25130

Response to Submissions | Response to Test of Adequacy Comments 2 and 2A Bullecourt Avenue (SSD-97092958)

This letter has been prepared by Beam Planning on behalf of Mirvac Residential (NSW) Developments Pty Ltd (the Applicant) in response to the items raised by the Department of Planning Housing and Infrastructure (DPHI) at the Test of Adequacy (ToA) stage following the lodgement of the Response to Submissions (RtS) for SSD 97092958. Those comments provided as part of the Test of Adequacy (ToA) stage as well as those provided in the subsequent Request for Information (RFI) are addressed in **Table 1** and **Table 2** respectively.

TREE REMOVAL SUMMARY

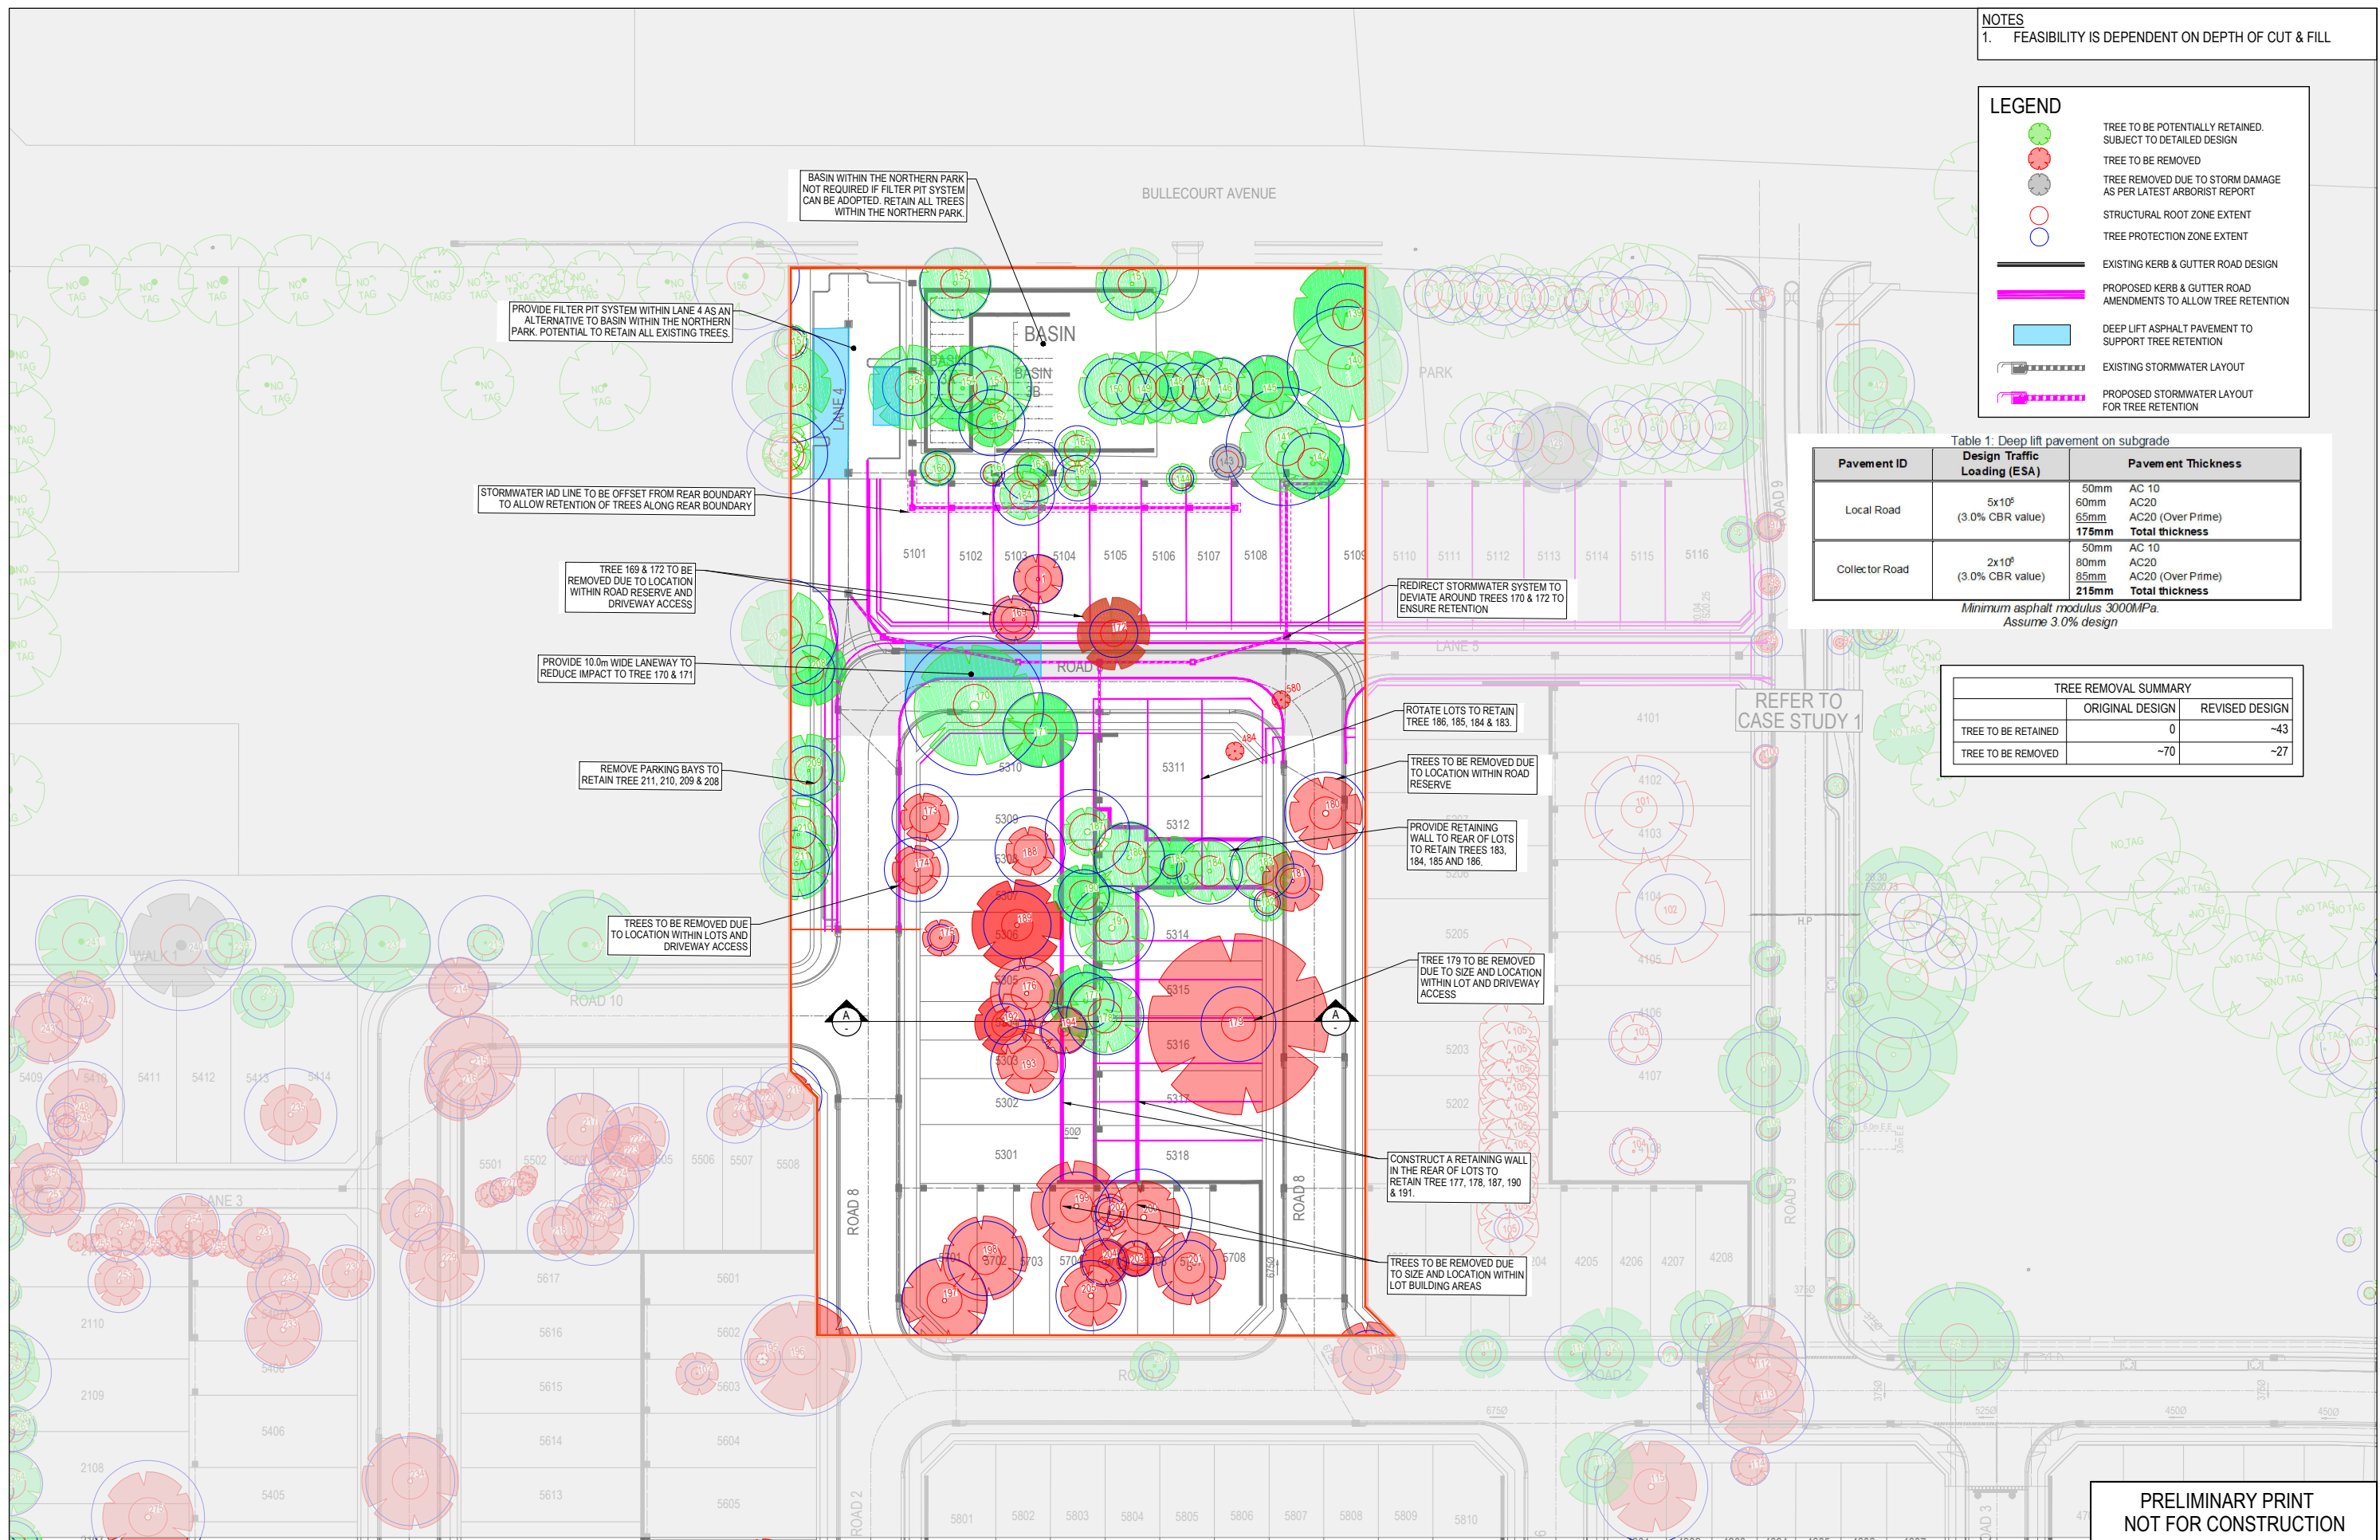
After a review of the additional information submitted, further justification is required on the avoidance of impacts to biodiversity outside of the C2 zoned land. The justification provided to the department seeking reliance on compliance with the DCP, as well as engineering matters, are insufficient to demonstrate that all reasonable actions have been implemented to avoid impacts upon the Cumberland Plain Woodland community. Further information is required for assessment, which may result in a change to lot numbers, including the consolidation of a number of lots to retain vegetation, for Stages 3 onwards. This could result in larger lots subject, which would be subject to future DA's for assessment. Attachment A indicates areas of vegetation that could be retained (outside the identified areas of contamination), however there may be other alternatives for retention of the vegetation.	Further consideration has been given to the avoidance of CPW outside the C2 zone which has resulted in additional opportunities being implemented for the retention of CPW Trees 217, 56, 400, 403 and 408. Additional investigations into the other CPW trees identified in Attachment A of the Department's letter has revealed that Trees 85, 108, 275 and 276 were originally assessed as having existing areas of decay. Following storm damage experienced in January 2025, the trees have now been assessed as having a short useful life expectancy and may present a danger to future residents in the form of dropping limbs. Given their deteriorated condition and limited retention value, retaining these trees is not considered warranted, particularly where doing so would require the removal of residential dwellings from the proposed development.

A detailed explanation of how the revised scheme facilitates this further avoidance is provided at: • Section 4.1: Tree 56 can be retained through a clause 4.6 variation to clause 6.13 of the CB LEP 2023, which comprises a reduction in width of the Road 2B carriageway. • Section 5: Trees 217, 400, 401, 403 and 408 can be retained through a reduction of two residential lots in Stage 5 and one residential lots in Stage 7. Further explanation of the retained trees and trees which remain proposed to be removed can be found at the Arboricultural Summary at Appendix W.
Other information required includes: • An amended plan showing additional vegetation for retention (see Attachment A) • A consolidated plan clearly showing where retention of trees (with Cumberland Plain Woodland trees and others clearly identified) has been achieved outside of the C2 zoned land. • Details of the vegetation retained (identified on a plan) as a result of the proposed 390 lot layout compared to the 430 lots under the planning proposal. • Retention of additional Cumberland Plain Woodland vegetation as outlined in various options in the Response to Test of Adequacy Comments document.	• Vegetation retention is shown in Figure 21 of the updated BDAR (Appendix D) and in updated Civil Plans (Appendix B). • The original yield numbers were determined at the Planning Proposal stage, and are not available in plan format. This figure represented a theoretical maximum determined before detailed design refinement and the consideration of site-specific constraints. Subsequent investigations, particularly the assessment of biodiversity impacts, have necessitated a reduction in the overall development yield. This is evident in both the VPA and clause 6.34(2) of the Canterbury Bankstown LEP 2023, both of which reference a maximum provision of 430 dwellings being delivered on the site. It is further noted that the final lot layout will be available under SSDA-109921491 as this current application only seeks consent for super lots in some locations. • Trees 217, 56, 400, 401, 403 and 408 are now proposed to be retained as detailed in Sections 4.1 and 5.

In order to further avoid the loss of CPW across the site, a revised design has been prepared which amalgamates lots to facilitate a bulk earthworks plan that can safely retain 7 existing CPW trees in Stages 5 and 7. The redesign results in a retention of 7 additional CPW trees and by reducing the total number of lots in Stage 5 by two, and one lot in Stage 7.

Since the issue of the RFI, further opportunities have been found to retain additional CPW across the residential zoned land within the site. An amended design has been prepared which identifies the retention of Trees 56, 217, 400, 401, 403 and 408 (refer to civil plans at **Appendix B**). This has been achieved by implementing a kerb blister on Road 2B and amalgamating lots under the future SSDA 2, resulting in a reduction of 3 future residential lots.
